Conservation Officer comments

**ADC Planning Consultation
Conservation/Design Officer Response**

Application Number	Y/58/17/PL
Address	Stakers Farm North End Road Yapton BN18 0DU
Description	Conversion of barn to form to 2 No. dwellings; detached garage & conversion of part link single storey building to garaging. This application may affect the setting of a listed building & affects the character & appearance of the Main Road/Church Road Conservation Area.
Case Officer	<u>Mr S Davis</u>
Date	29 TH November 2017

PROPOSED FIRST FLOOR BARN 2

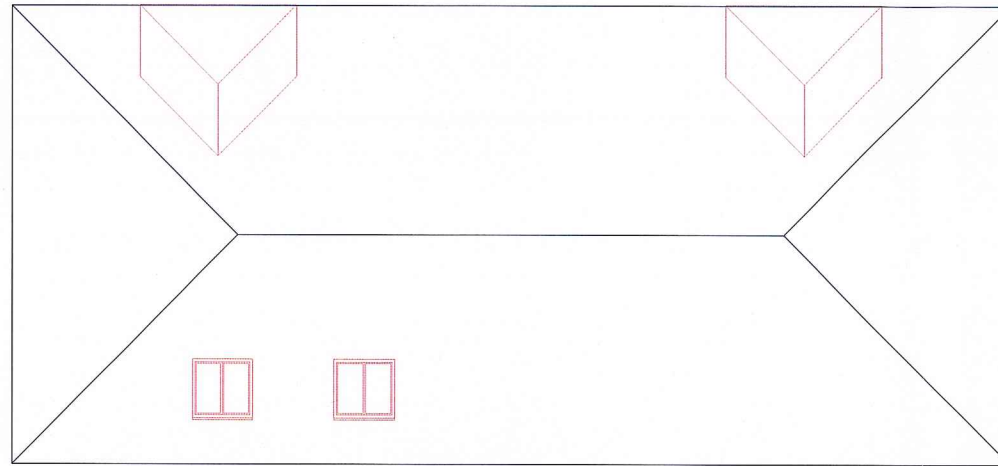
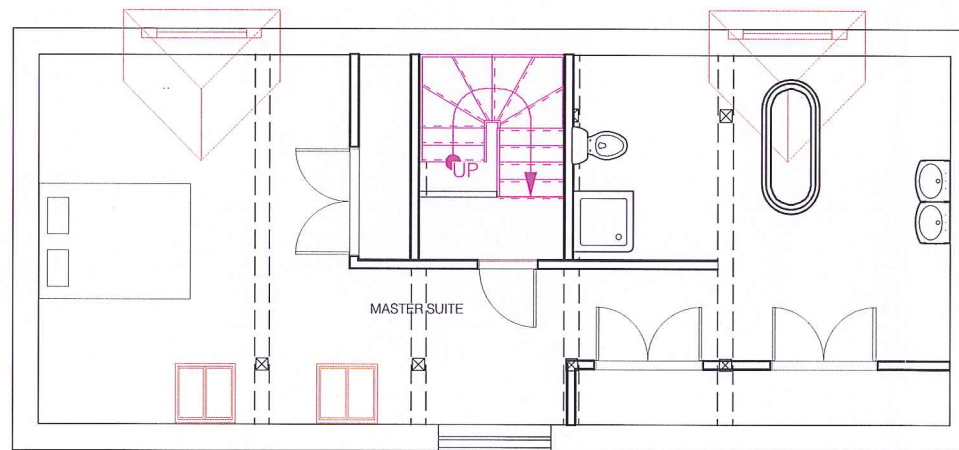
remove and obliterate many of the distinctive features of the agricultural buildings, and the proposed additional features , including dormers, chimney flues, glazing and rooflights.

PROPOSED ELEVATIONS NEW WORKS LINED RED

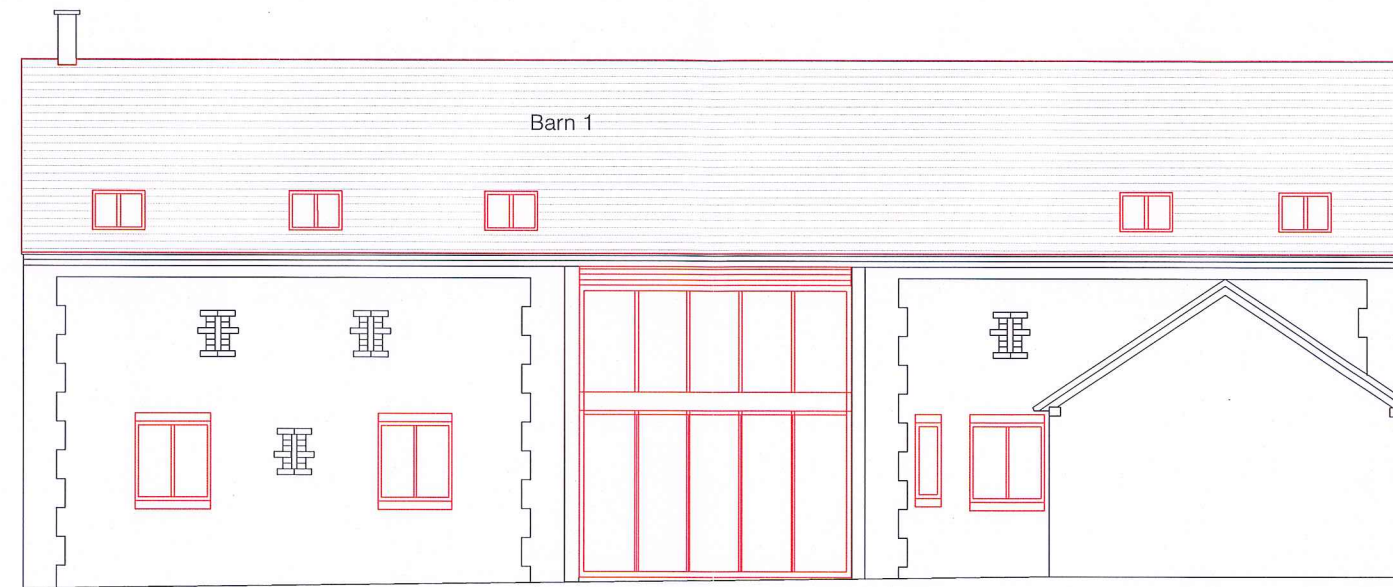
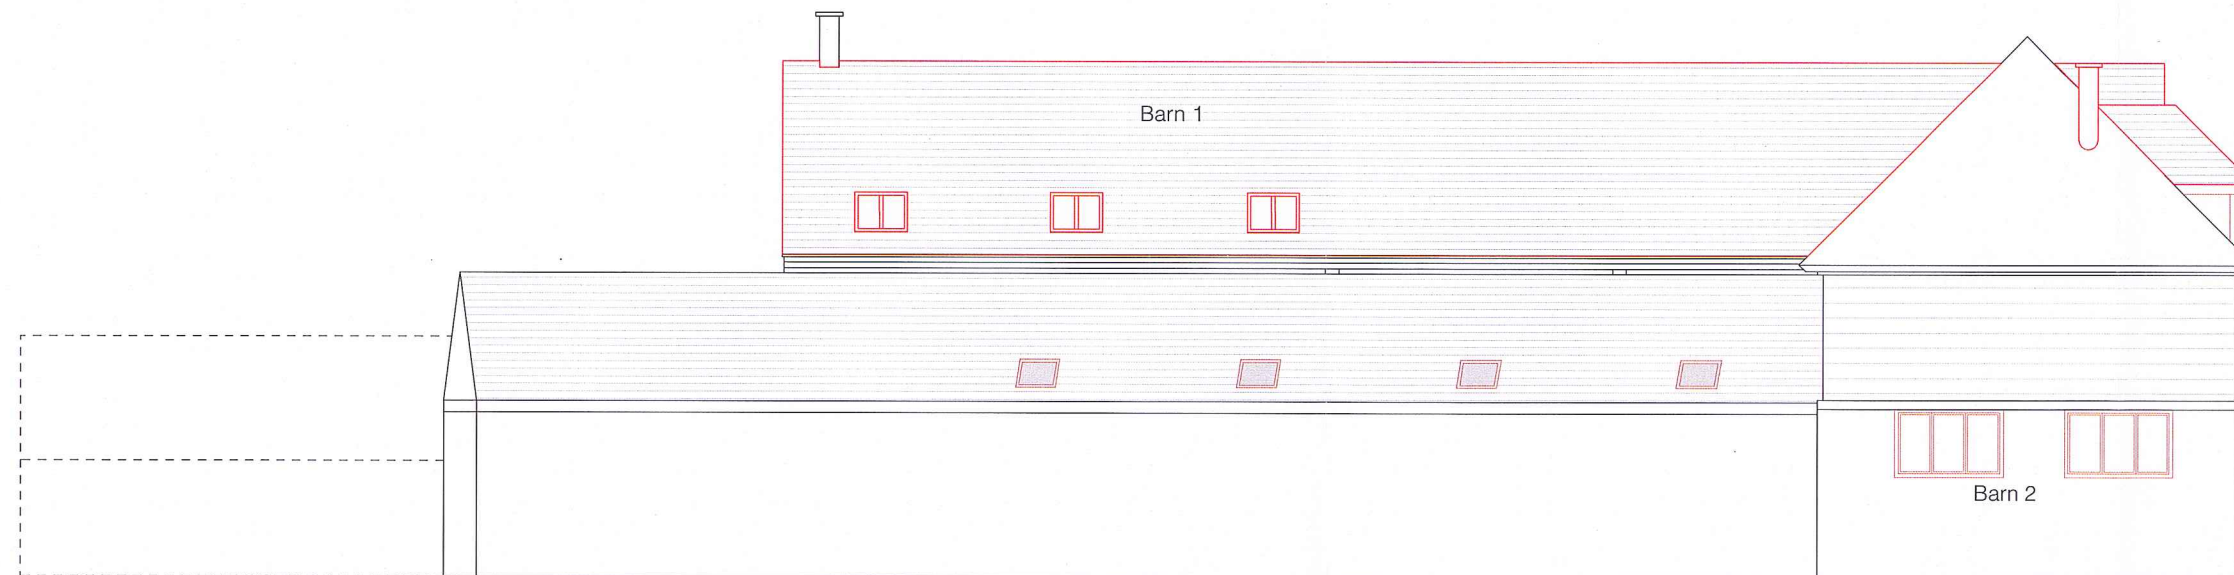
It is considered that the proposed does not meet these basic criteria in terms of relating the proposed to the existing. The proposed scheme is considered to

The resultant proposed plan does not reflect or respect the agricultural origins and history of the farm buildings, and I therefore object to this proposal.
